DELEGATED ADVERTISEMENT DECISION

The application site is located on the public footway adjacent to 53-55 High Street, Ruislip, within Ruislip Town Centre and the designated Secondary Shopping Area. The site also lies within the Ruislip Village Conservation Area. The surrounding area is characterised by a mixed-use High Street environment comprising predominantly two- to three-storey buildings of inter-war origin constructed in brick, with commercial uses at ground floor level and residential accommodation above.

Installation of 1No. BT Street Hub Unit and associated advertisement panels on either side of the unit

PROPOSED BLOCK PLAN
SCALE 1:500

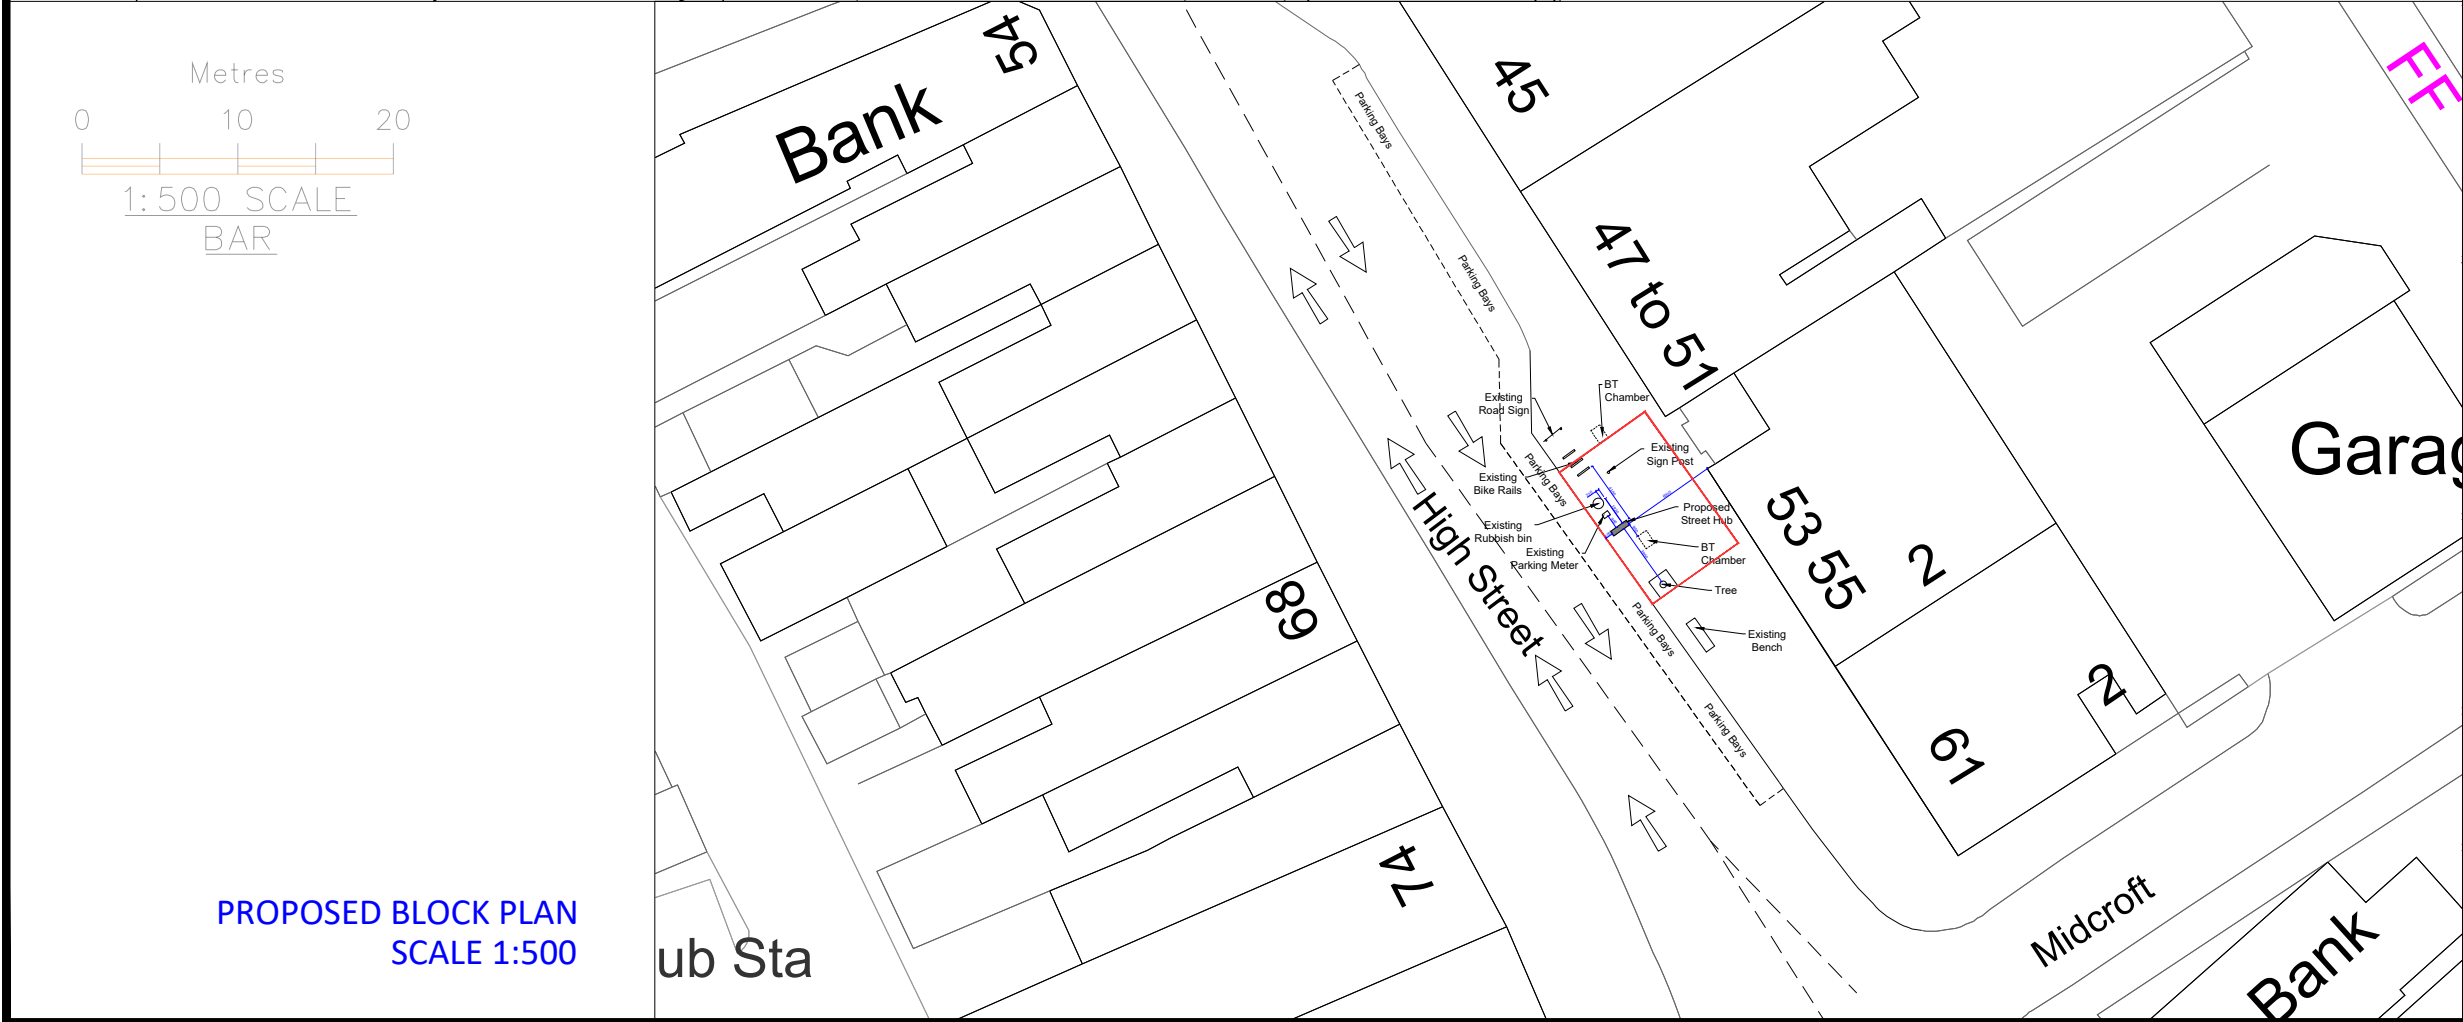
The proposed Street Hub would incorporate large internally illuminated digital screens on both sides

of a freestanding structure. These screens, by reason of their brightness, changing images and scale, would be visually dominant and would draw the eye in wider views along the High Street. They would compete with traditional shopfront signage, introduce an incongruous modern advertising feature, and create an incrementally harmful illuminated environment. The proposal would therefore fail to integrate successfully into its context and would appear overly prominent within the street scene.

The site already contains a concentration of street furniture, including an existing kiosk, parking meter, signage, cycle racks, litter bin, bus stop infrastructure and cafe seating. The introduction of an illuminated advertising structure in this constrained footway environment would exacerbate visual clutter and detract from the character and appearance of the High Street and the wider Conservation Area.
